CITY OF ALBUQUERQUE

**Re: Albuquerque Christian School,
4931 McLeod NE
Request for Certificate of Occupancy
Transportation Development Final Inspection**
Engineer's/Architect's Stamp dated 04-12-18 (F17D094)
Certification dated 1-14-19

SITE PLAN

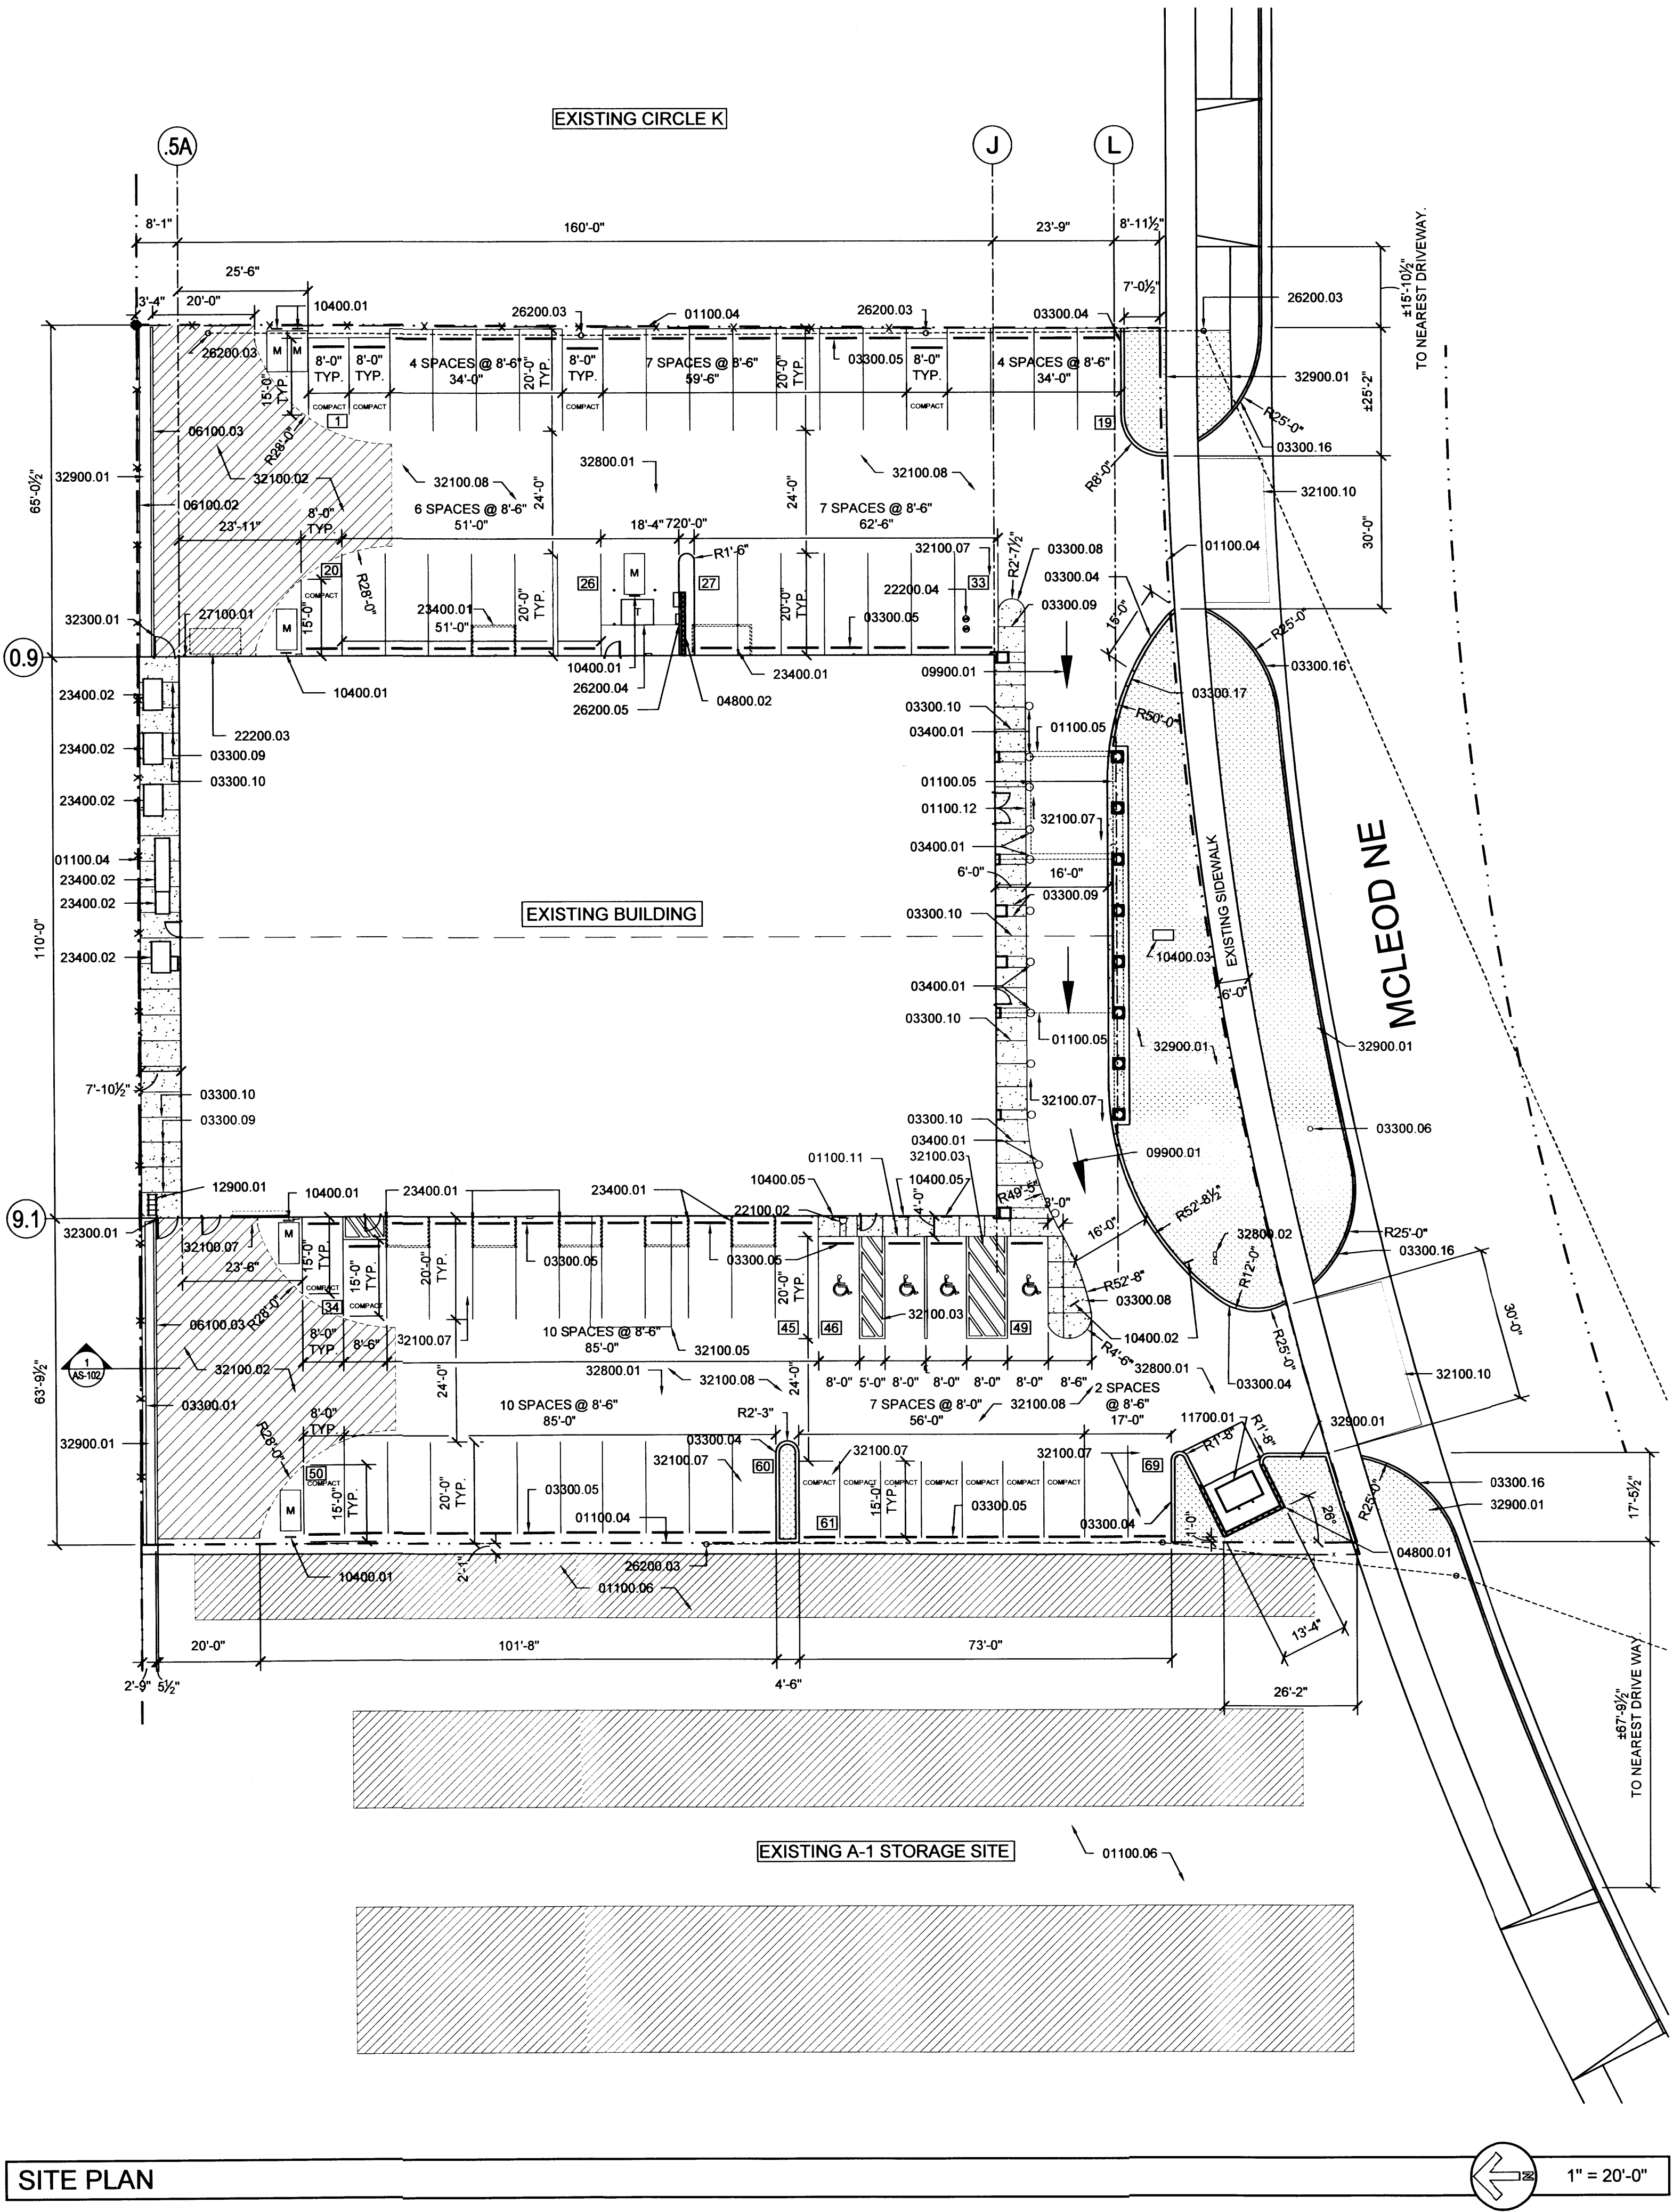
- Please fix the problem of fence being in the middle of the parking spot by either cross striping the space to remove one of the parking spaces or by removing the fence.
- The address on the certification letter and the application do not match.
